PLANNING AMENDMENT

Application No. **H16/0404/97**
 Date Registered **20 JUN 1997**
 Case Officer **OC**

**LAND TO NORTH OF WYGATE PARK DISTRIBUTOR ROAD, WYGATE PARK,
 SPALDING, Lincs.**

**LAYOUT REVISED TO INCORPORATE 14
 DWELLINGS. PLOT SUBSTITUTIONS AND
 THE RE-ALIGNMENT OF ESTATE ROAD.
 AS DISCUSSED WITH D. ROBERTS.**

drg. no.
 96010/001 B

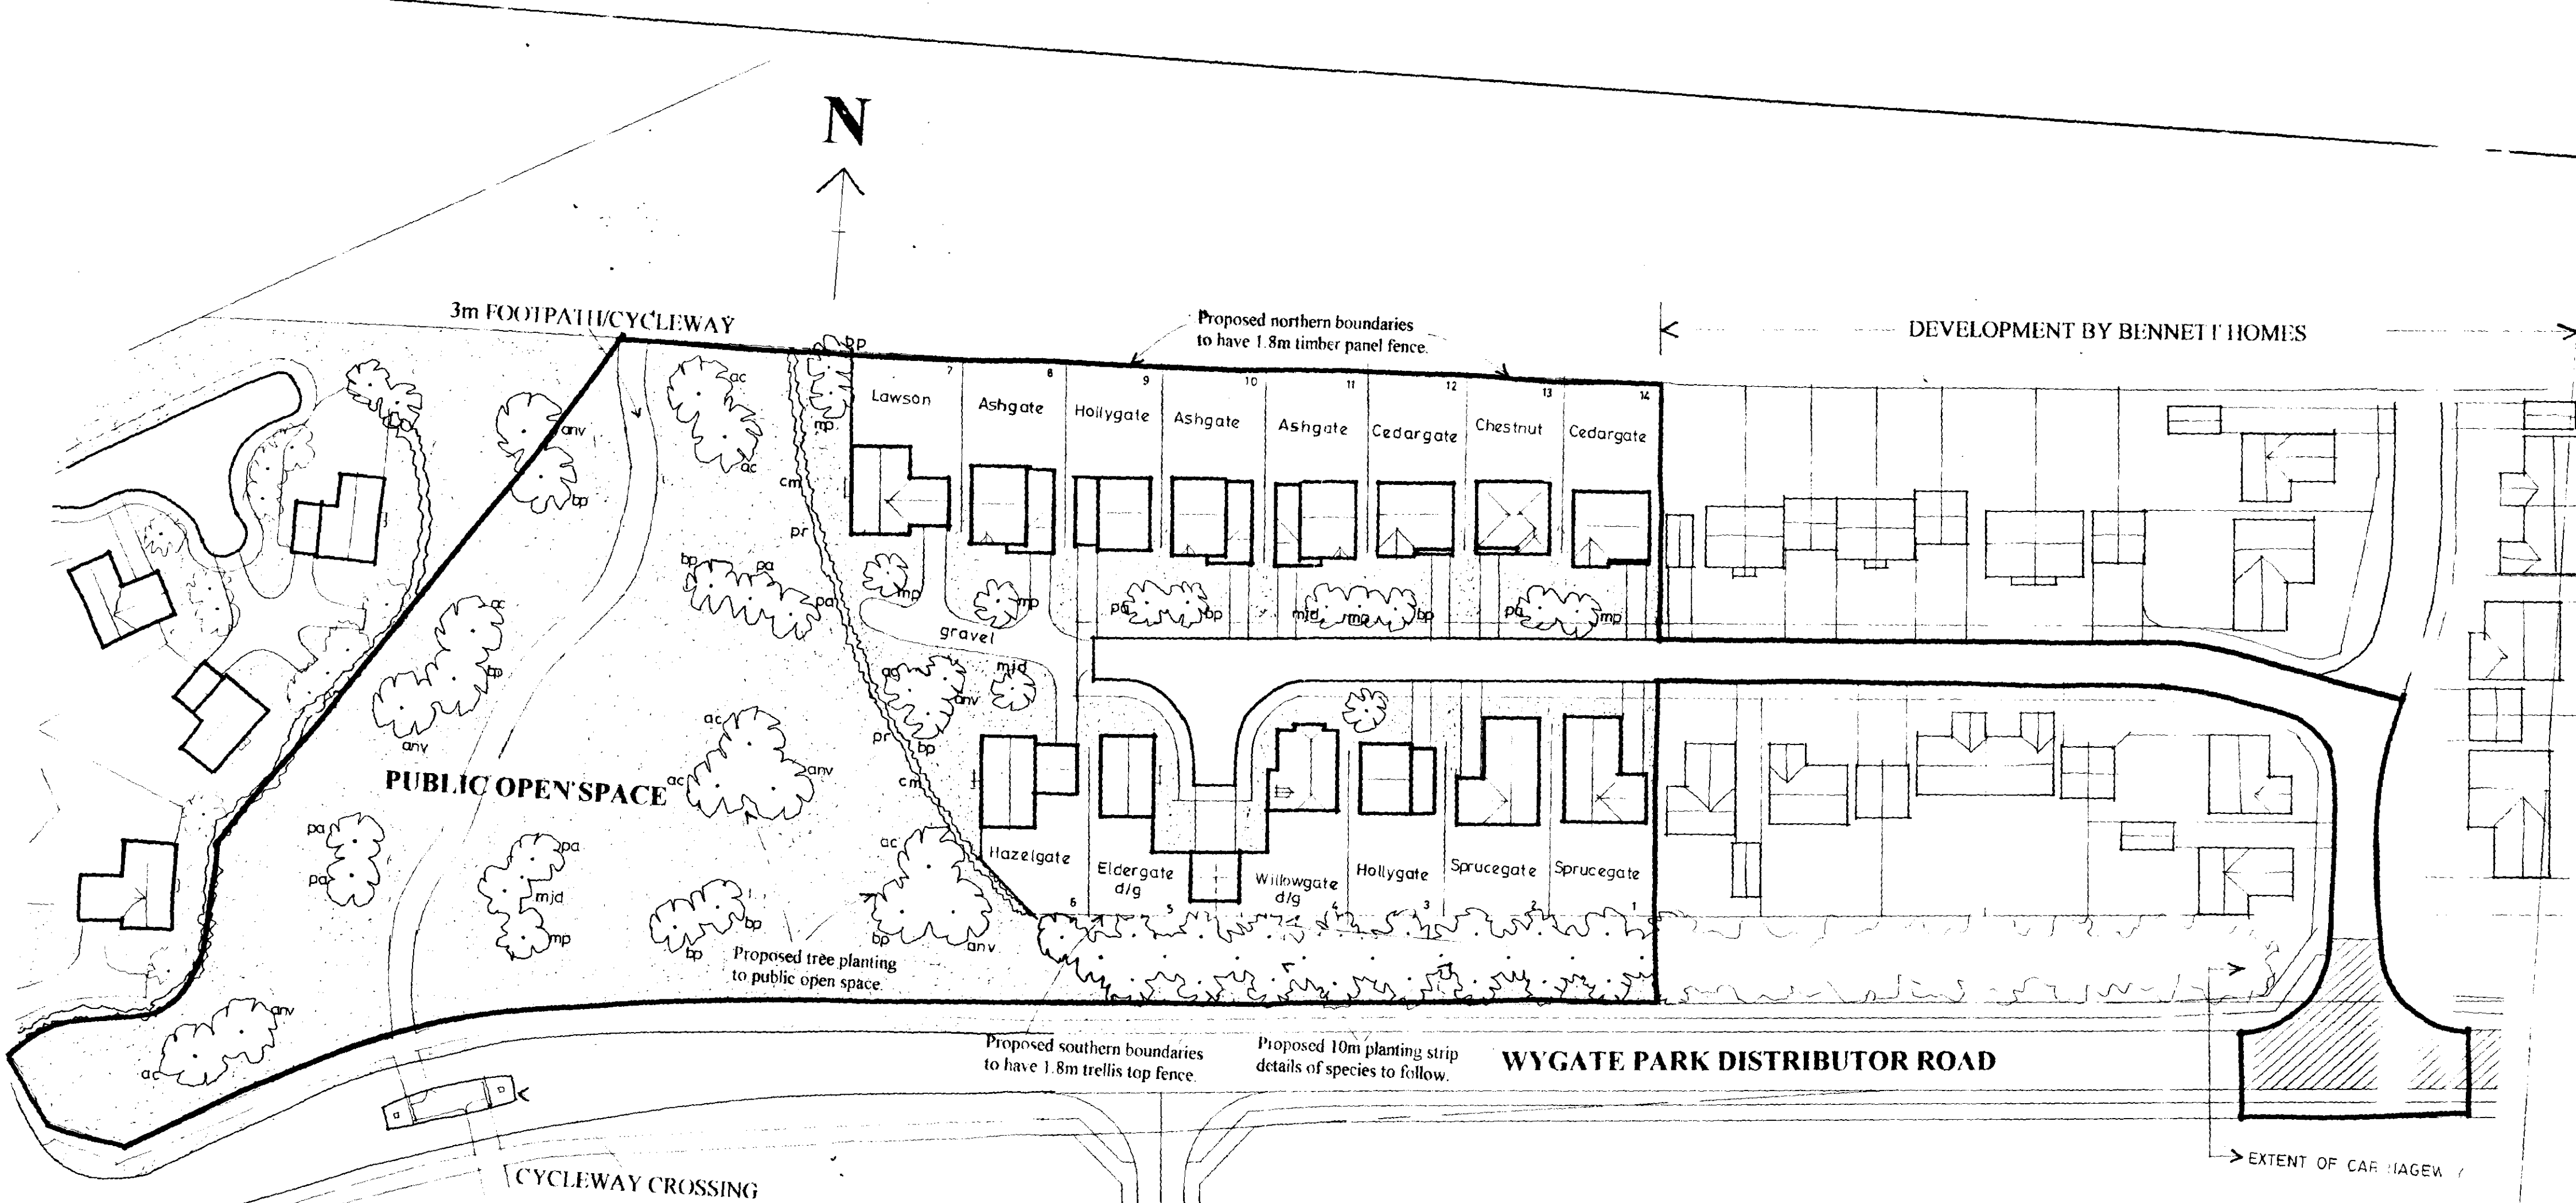
Amendment: Layout revised to incorporate 14 dwellings. Plot
substitutions & realignment of estate road
